Your ref: SSD 9063
File no: MC-18-00001

Re: SSD 9063 - Tallawong Station Precinct South (formerly known as Cudgegong Road Station South) - 69-79 Schofields Road, Rouse Hill

ATTACHMENT A

Fraxinus oxycarpa 'Raywoodii'

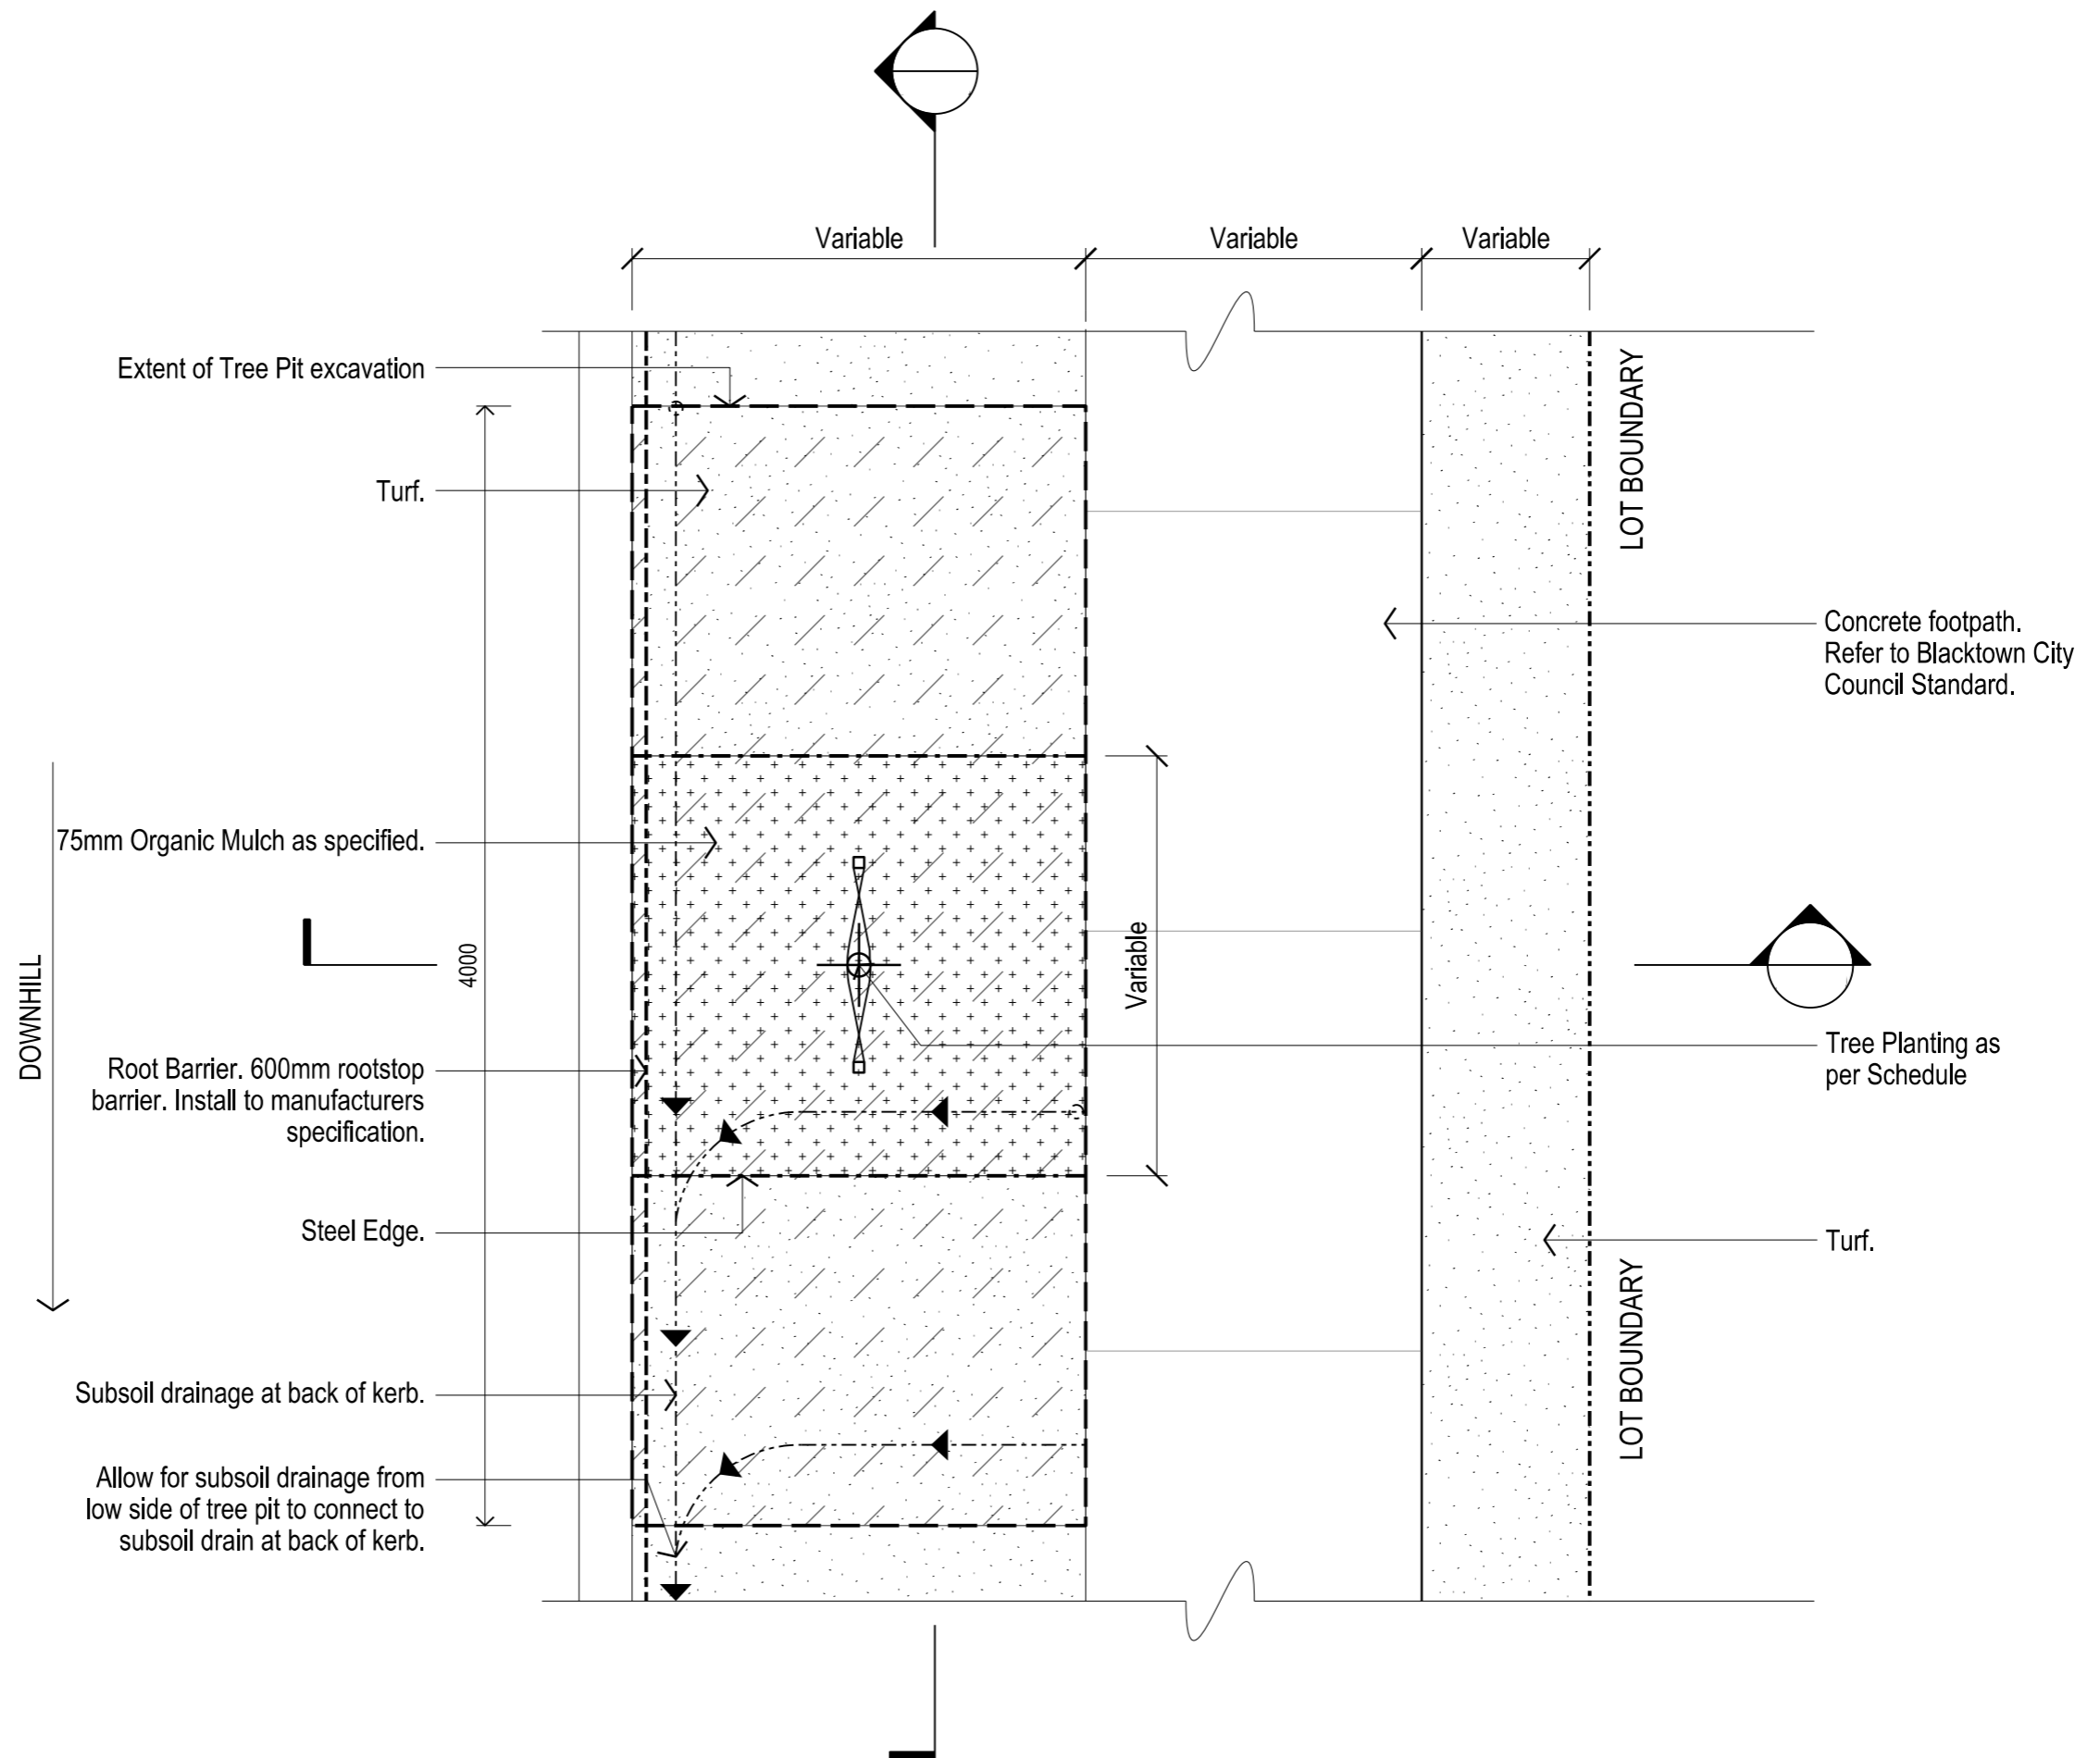
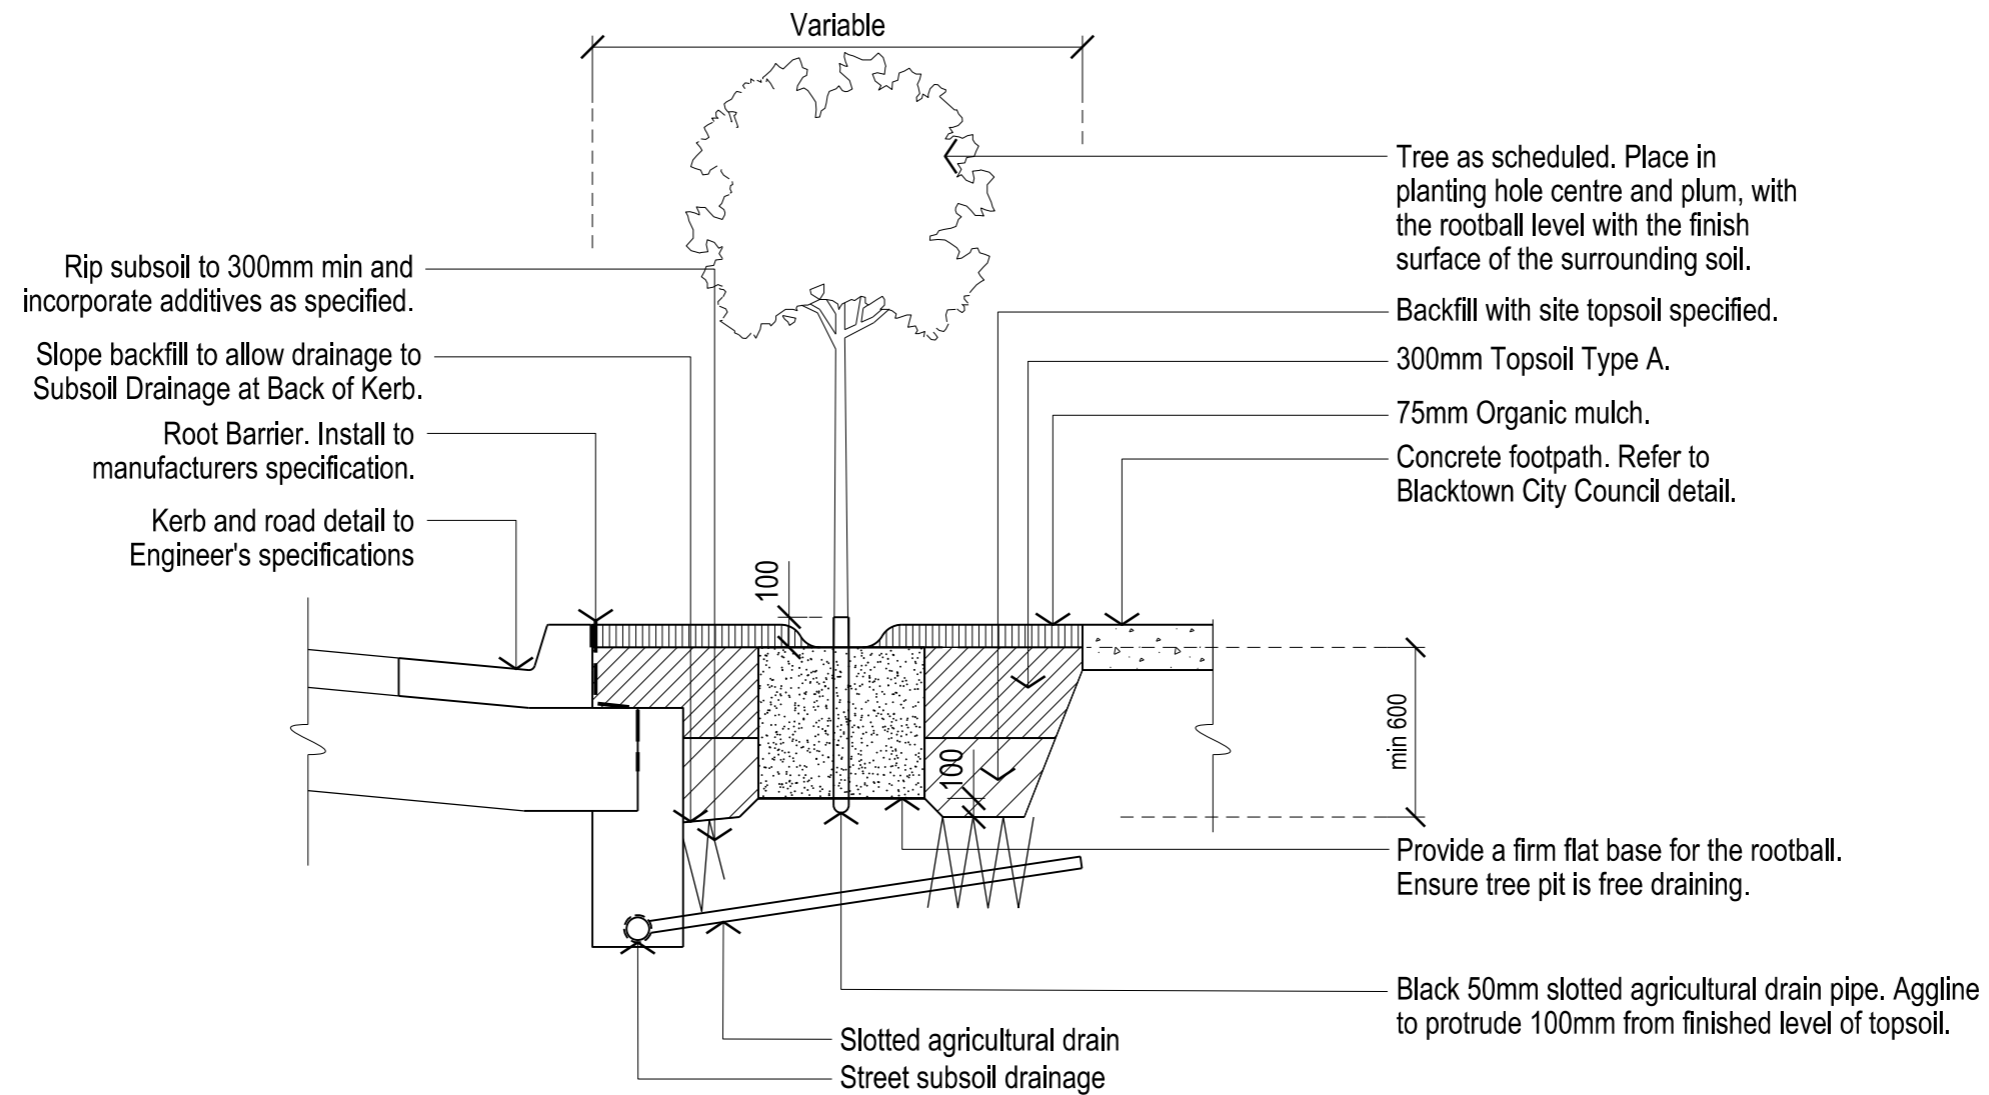
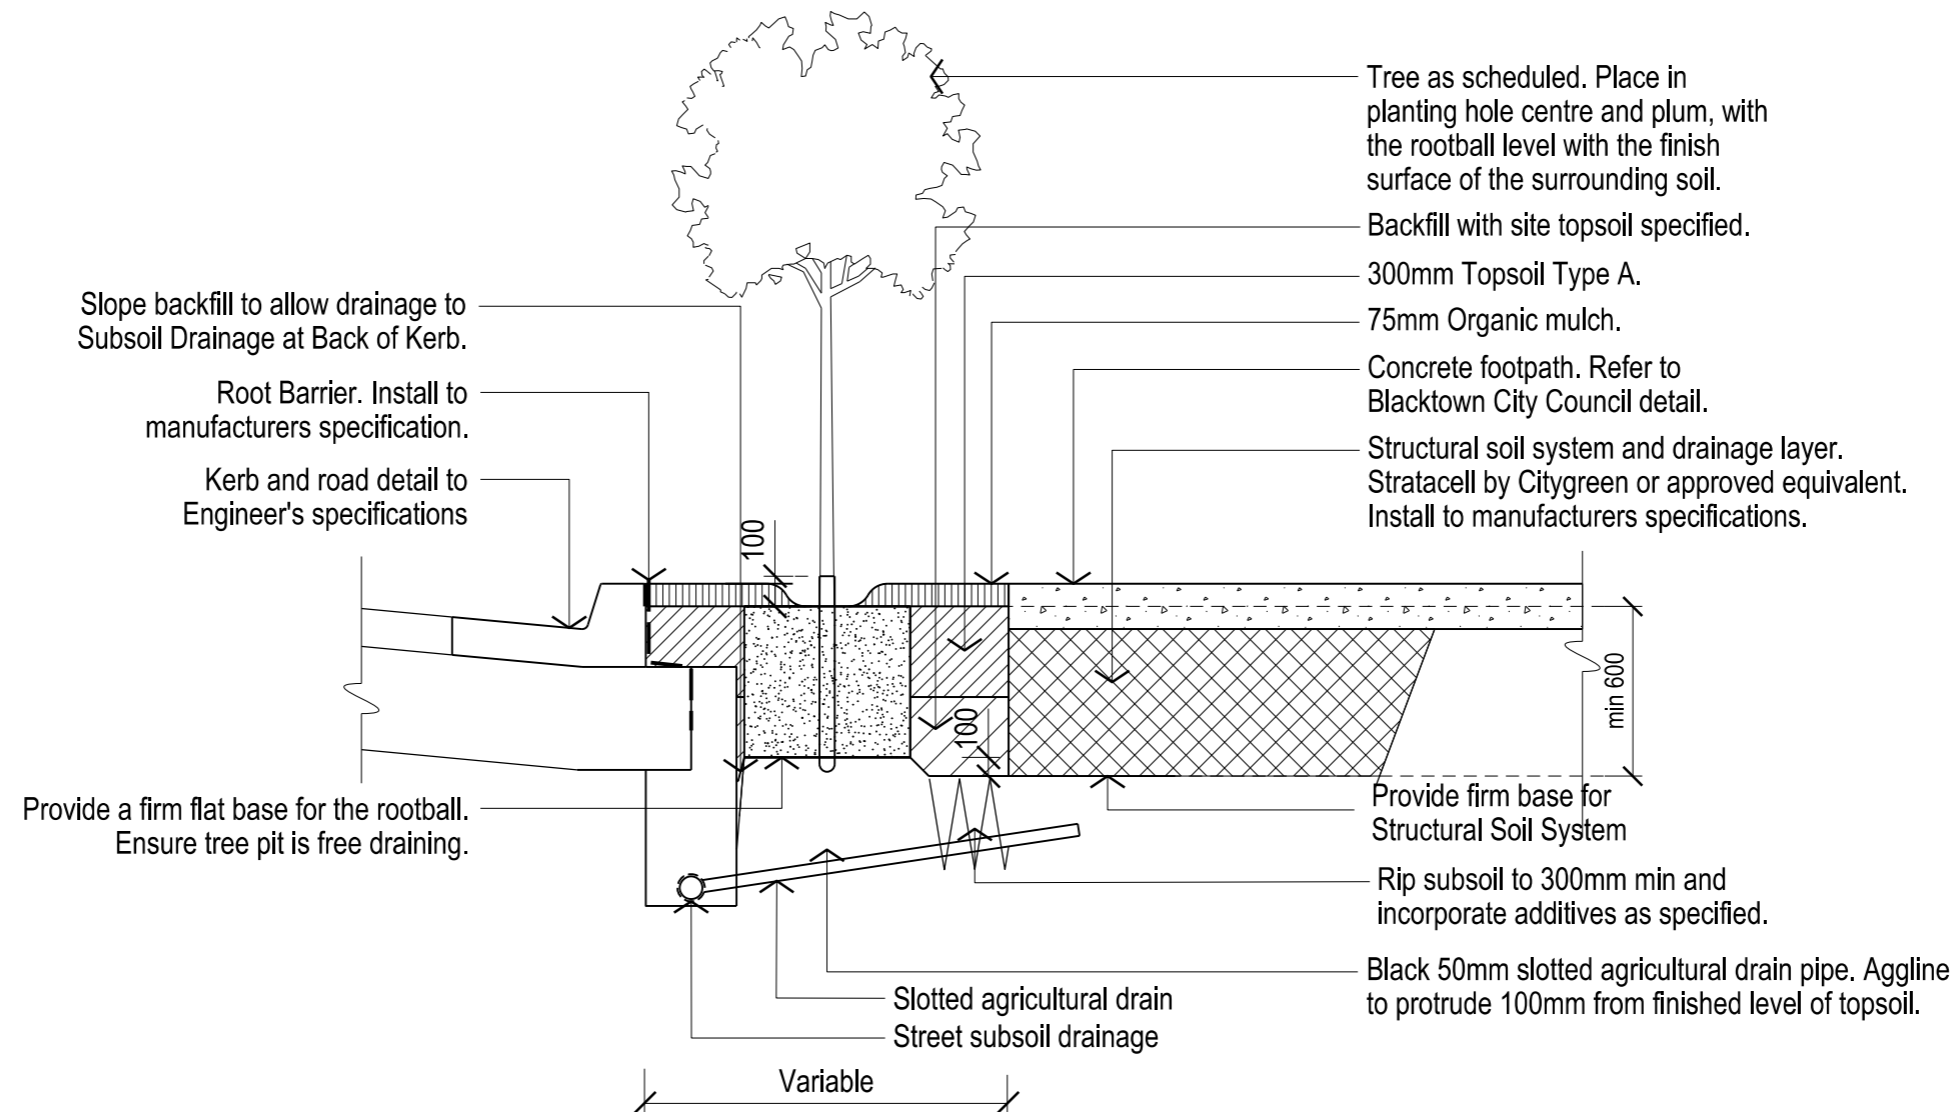
- h) No *Fraxinus griffithii* as street trees, alternatives *Fraxinus pennsylvanica* 'Urbanite' or 'Cimmaron.'
- i) Root barrier on kerb and path side of tree pits.
- j) Porous paving finish on street trees and plaza plantings no mulch in these areas.
- k) No steel edging on tree pits that adjoin turf areas.
- l) Page 5 of landscape plan has unacceptable species *Sapium*, *Jacarandas* and *Eucalyptus* species, street tree species on page 18 are acceptable but *Fraxinus oxycarpa* 'Raywoodii' can only be used in plaza plantings not as a street tree species.
